**KIRKLEES METROPOLITAN COUNCIL
INVESTMENT & REGENERATION SERVICE**

DELEGATED DECISION TO DETERMINE PLANNING APPLICATIONS

Reference No:	2023/62/93230/W
Site Address:	8, Cross Church Street, Paddock, Huddersfield, HD1 4SN
Description:	Erection of single storey rear extension
Recommending Officer:	Tom Hunt

Officer Report

Description
FLOOR PLANS AND
ELEVATIONS AS PROPOSED

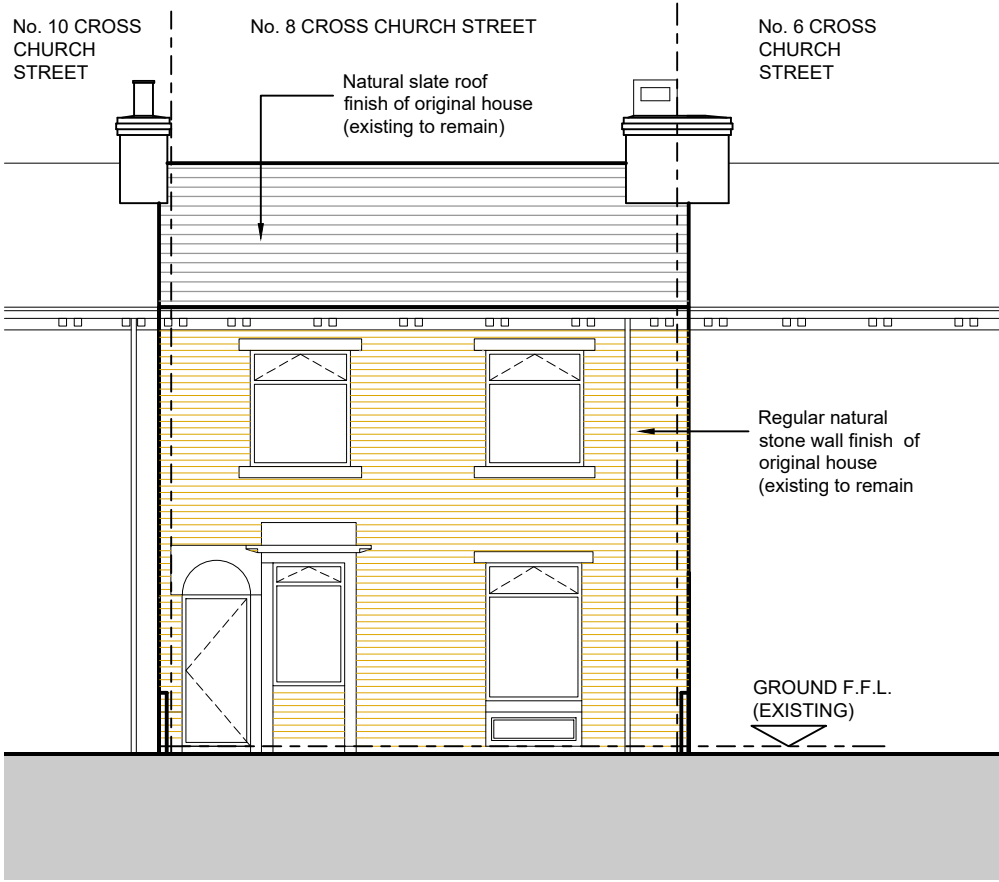
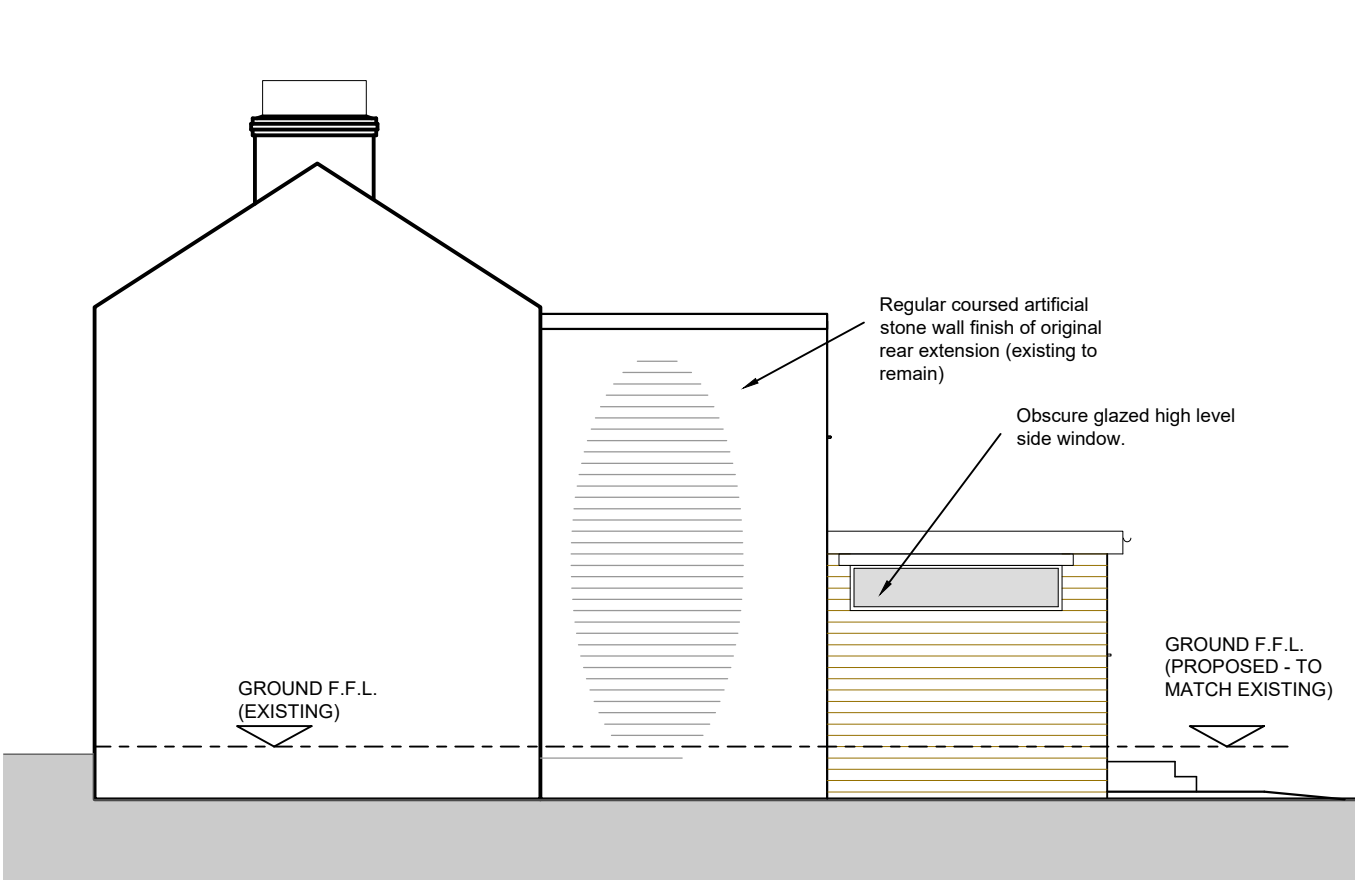
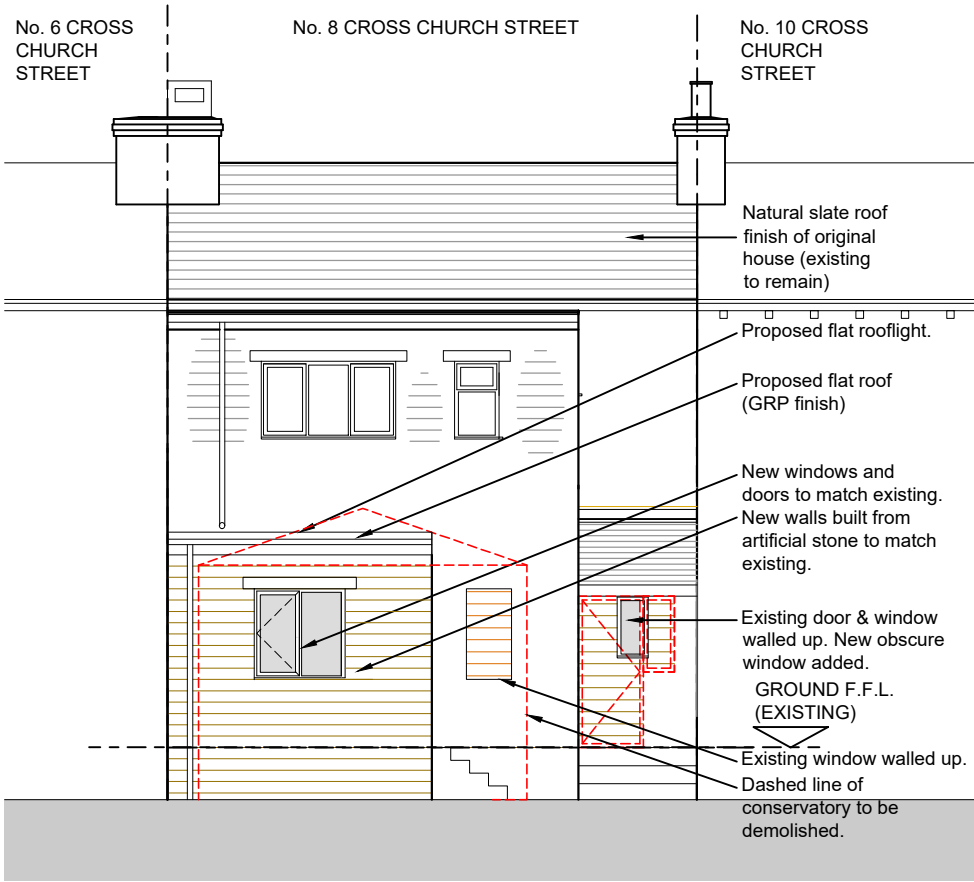
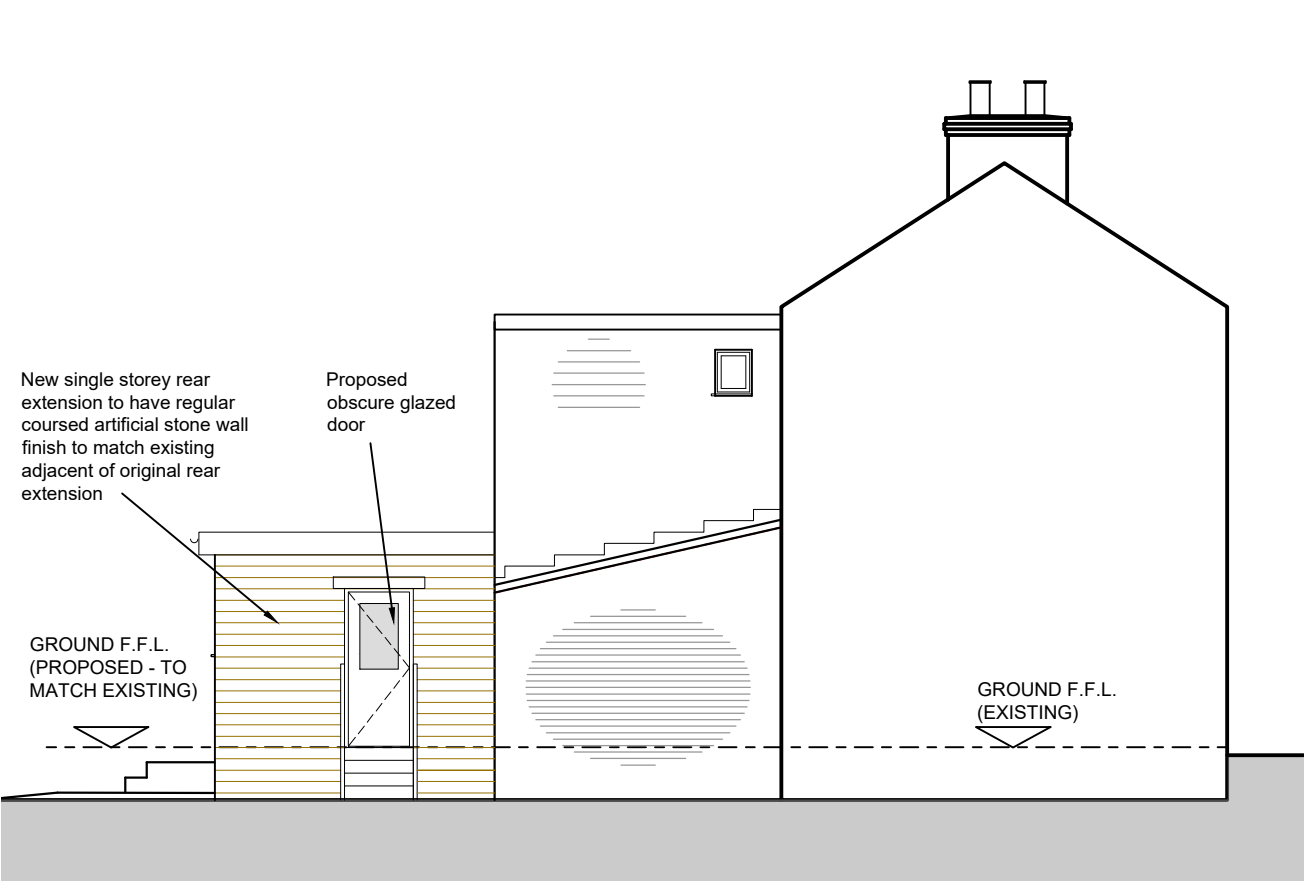
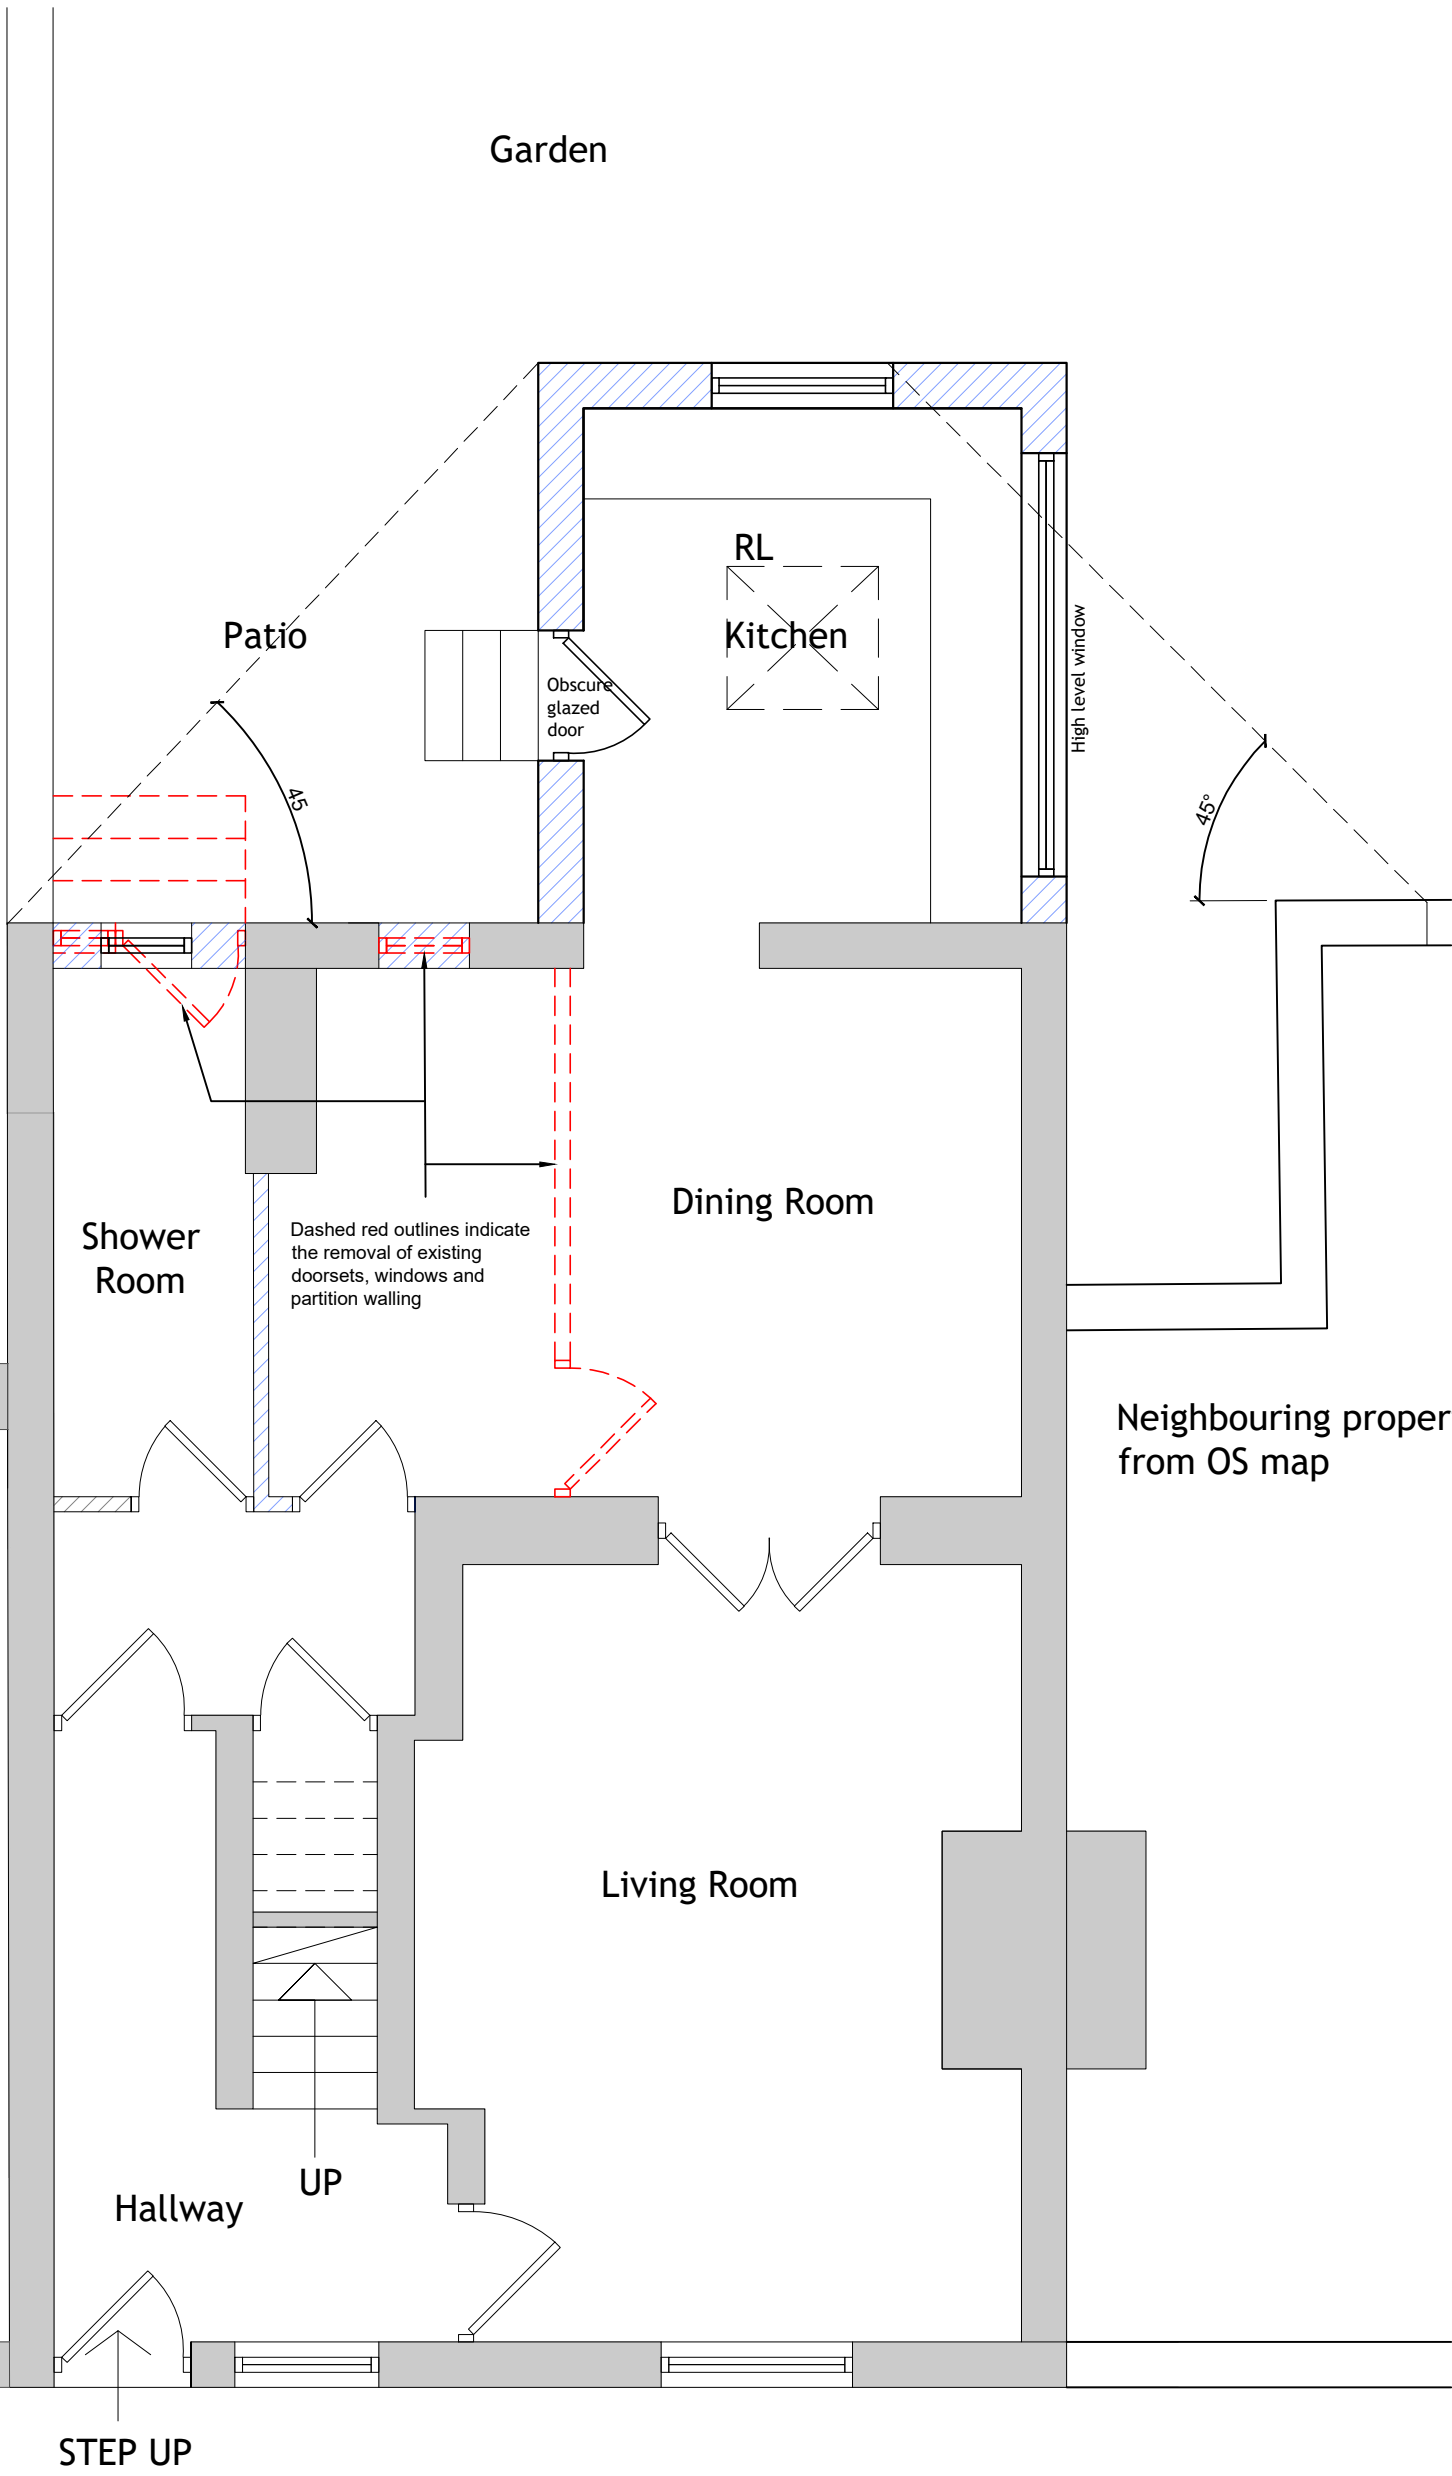
The proposed rear extension would be, at its width, half the span of the host and would project 3.8m from the two-storey rear projection. This would lead to a cumulative projection of ~7.5m from the original rear elevation of the host which would be the same as the previously existing conservatory (which was exempt from enforcement as previously stated in section ‘1.4 Background’). It would be set back 3.5m from the northern boundary and would be 3.5m height from ground level. This is a significant reduction in width from the previous application for a single storey extension ref 2022/94114.

While its proposed 3.5m height would comply with guidance setting the recommended roof height at 4m from ground level, it would exceed the recommended height of eaves however this would be to provide level internal access for its occupants and seeks to minimise its bulk and massing with a flat roof design.

The design would have a property gap to the northeast neighbouring boundary of 3.5m and would not comply with the southwest boundary. Viewing the proposal's dimensions within the limited scale of the plot, a narrower width extension to comply with this would either increase visual impacts and appear as an incongruous feature and would not be practicable for visual amenity or the needs of the occupants. The property gap to boundaries will be additionally assessed within the 'Residential Amenity' section of this report.

The extension subject of this application is to the north of No. 6, set forward of No. 6's own single-storey rear projection by approximately 3.7m and is built up to the shared boundary with an increase in eaves height of 0.5m compared to the previous hipped roof conservatory (since removed). The obscurely glazed high level window facing this neighbour would be 1.9m height from internal ground level and 2.4m height from ground level to the base of the window with associated restricted views; this would lead to improvements in the previous relationship with regard to privacy and overlooking. While the extension would not be able to demonstrate a 45° field of outlook to the rear projection by the extension being closer to the boundary and would overbear modestly, this would be similar to the previous longstanding impact of the conservatory with regard to overbearing. The extension would be to the northeast of the neighbour and would have very restricted impacts on overshadowing. In a finely balanced consideration, consistent with the Inspector's consideration of the impacts on neighbouring properties which did not raise harm as a determining factor, the limited additional overbearing impact is counterbalanced by there being very restricted impact on overshadowing and no harm to privacy or overlooking to this neighbour, as such this would be acceptable.

The proposed extension would have its flank elevation to this neighbour set 3.5m from the shared boundary and have an obscurely glazed panel to its door facing this neighbour. This would be to the south of the neighbour.

The proposal would have the result of built development extending ~7.5m beyond from the original rear elevation of the host which would have its visual impact in terms of overbearing be mitigated by its single-storey construction and set back from the boundary sufficiently meeting the 45° field of outlook as recommended in KDP 5 of the House Extensions and Alterations SPD. There would be no material loss of privacy to this neighbour.

The benefits of obscure glazing in further reducing loss of privacy to the neighbours is noted in the report and explicitly stated within the submitted drawing 'Location, Site, Proposed Floor, Roof and Elevation Plans. Drawing no. (100) 02. Revision: D' (received 12/01/2024). As such, the plans would be subject to condition two of the Decision Notice, and would not be required to be conditioned separately for residential amenity in accordance with advice set out in the Planning Practice Guidance on 'Use of planning conditions'.
